Helen Donaldson <hcd@portlandmaine.gov>

MMC: FW: Shaws TCP (CMP)

Eric Nevins <erich@portlandmaine.gov>

Maine Medical Center Site Enabling PH2		Phase 2 Work Zone Traffic Control Plan		FIGURE <b>2B</b>
Shaw Brothers Construction, Inc. 341 Mosher Road, P.O. Box 69 Gorham, Maine 04038 (207) 839-2552				
		DRAWN: M.E.	DATE: 4/24/19	
		DESIGNED: -	SCALE: 1"=100'	
		CHECKED: -	FILE: -	
		FILE LOC: -

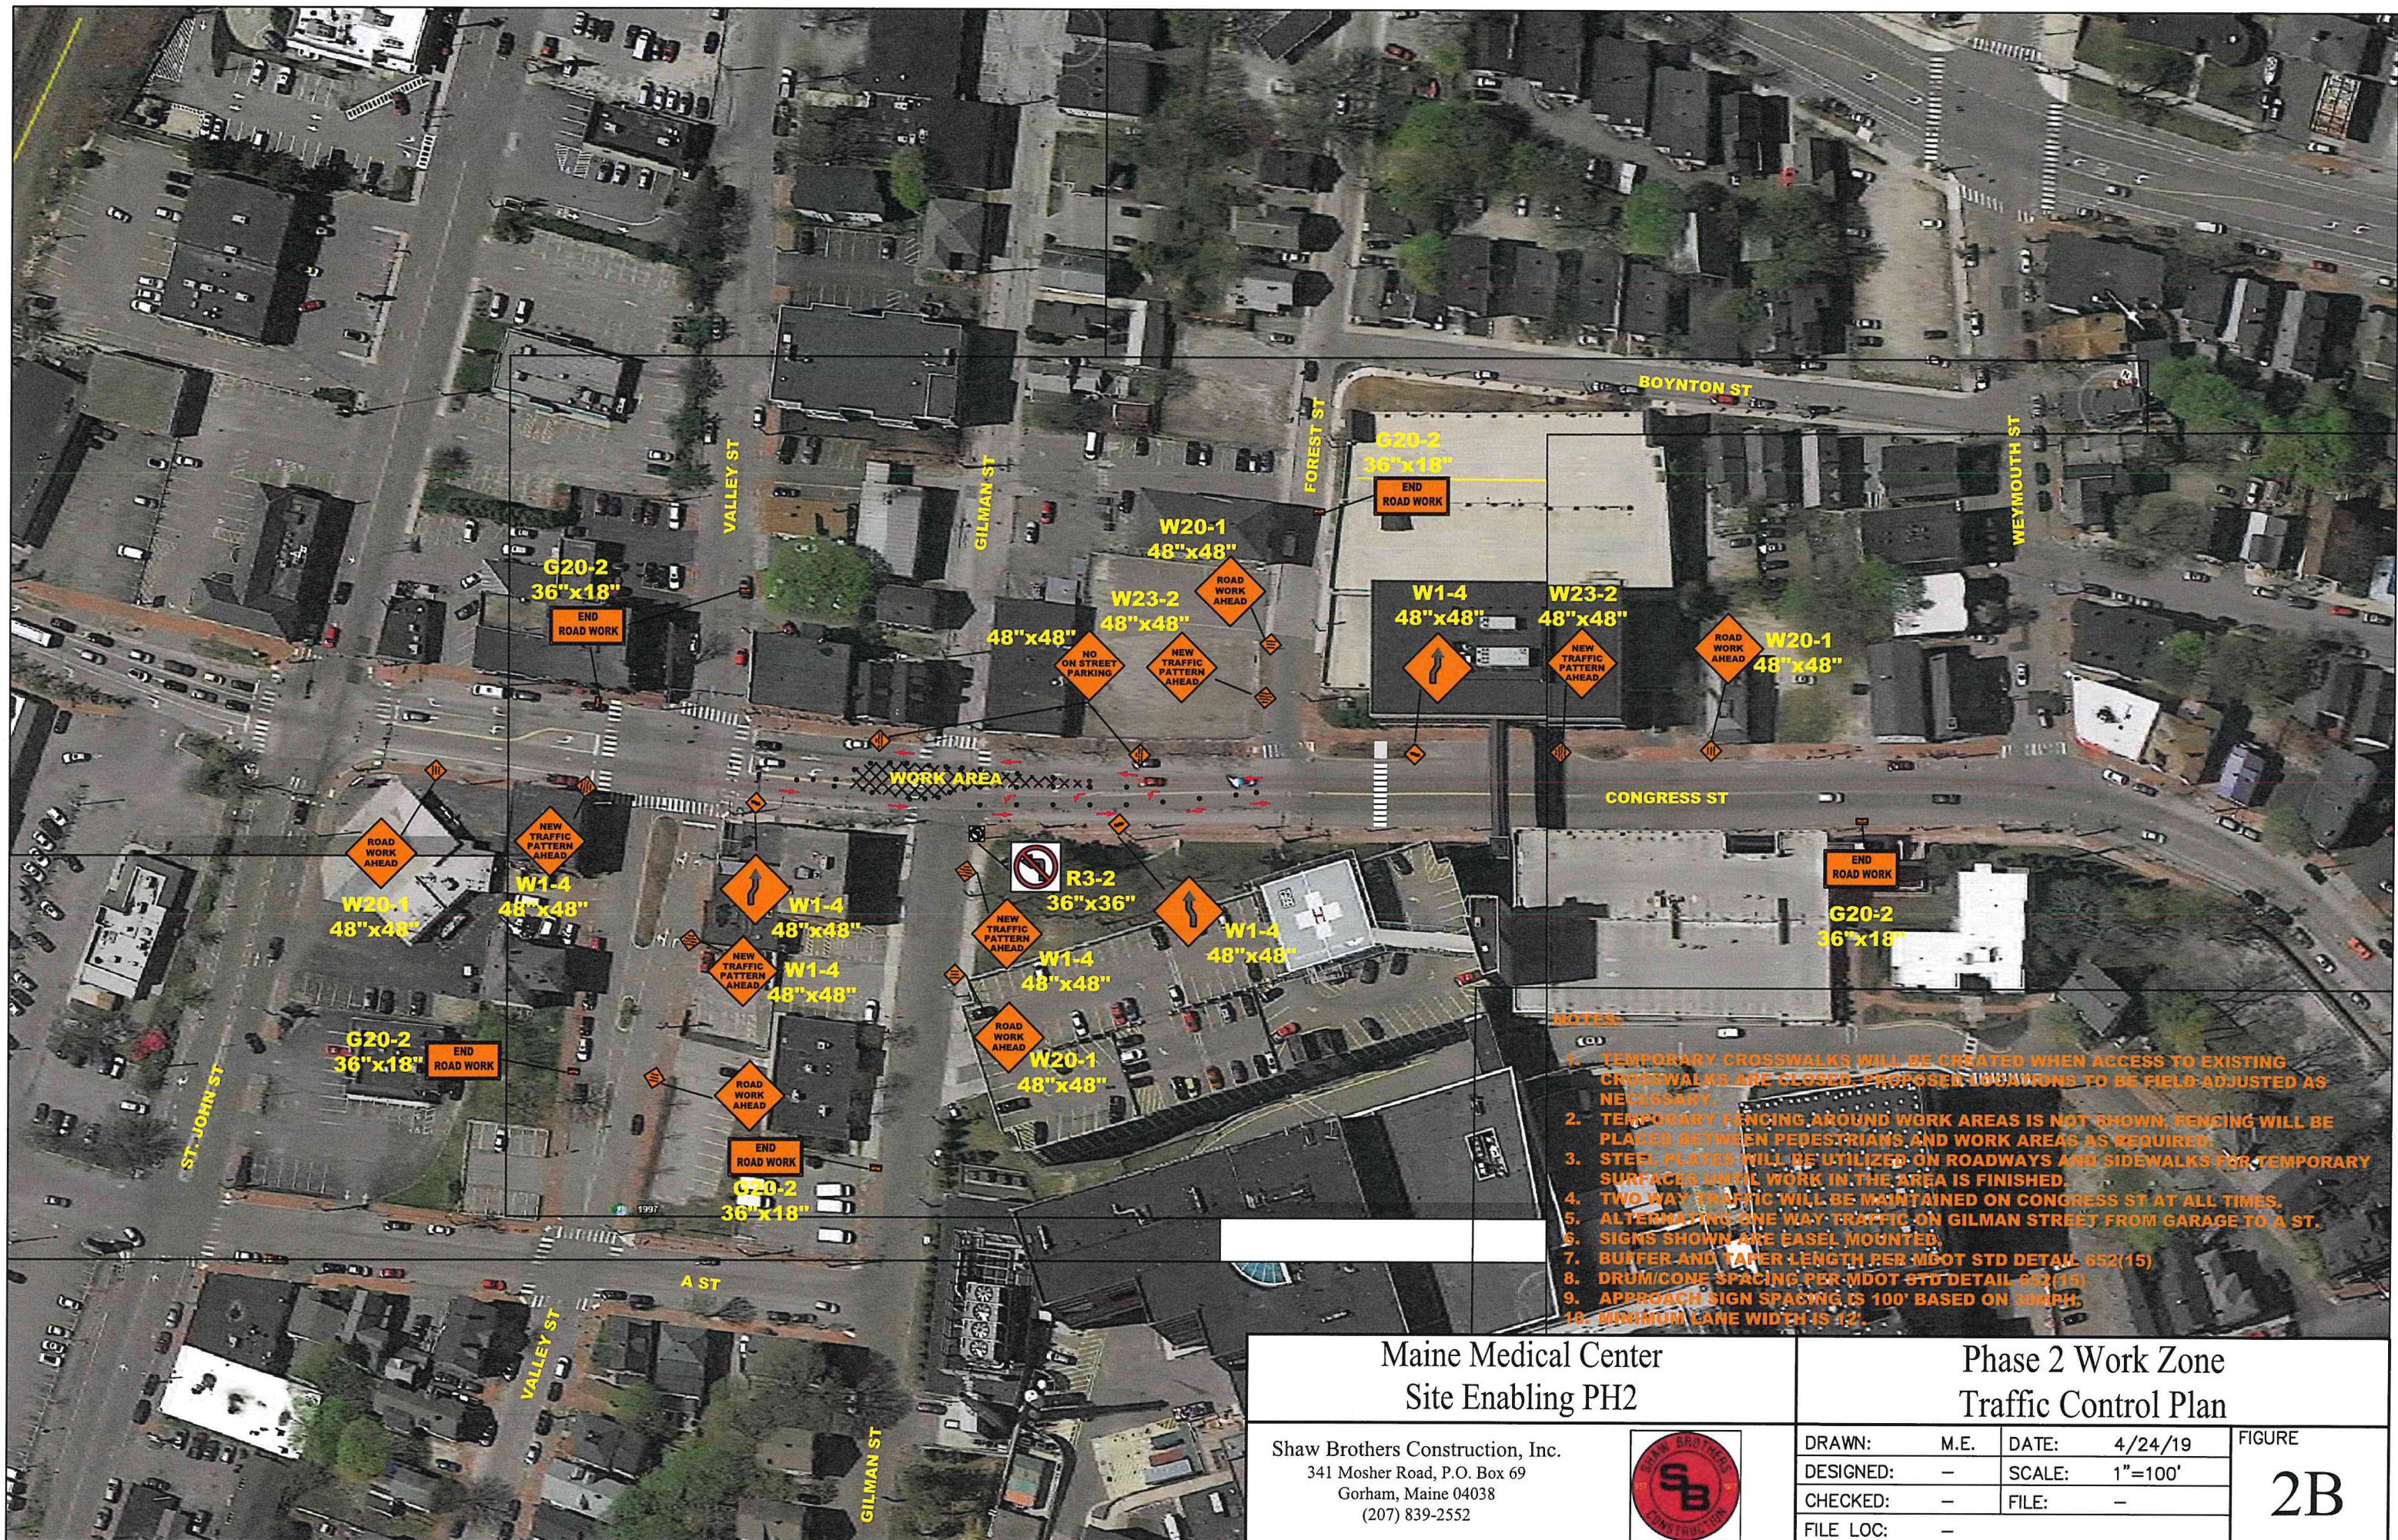
The only thing I see so far is on page 5 where the top of Gilman Street is closed there needs to be a flagger at Gilman and Park Ave to filter for the local only traffic and also to facilitate vehicles leaving Gilman Street heading in the wrong direction since egress to Congress will be closed. Due to my schedule this week and another Construction Management meeting this morning about another project I haven't had as much time to digest this plan as I think it deserves.
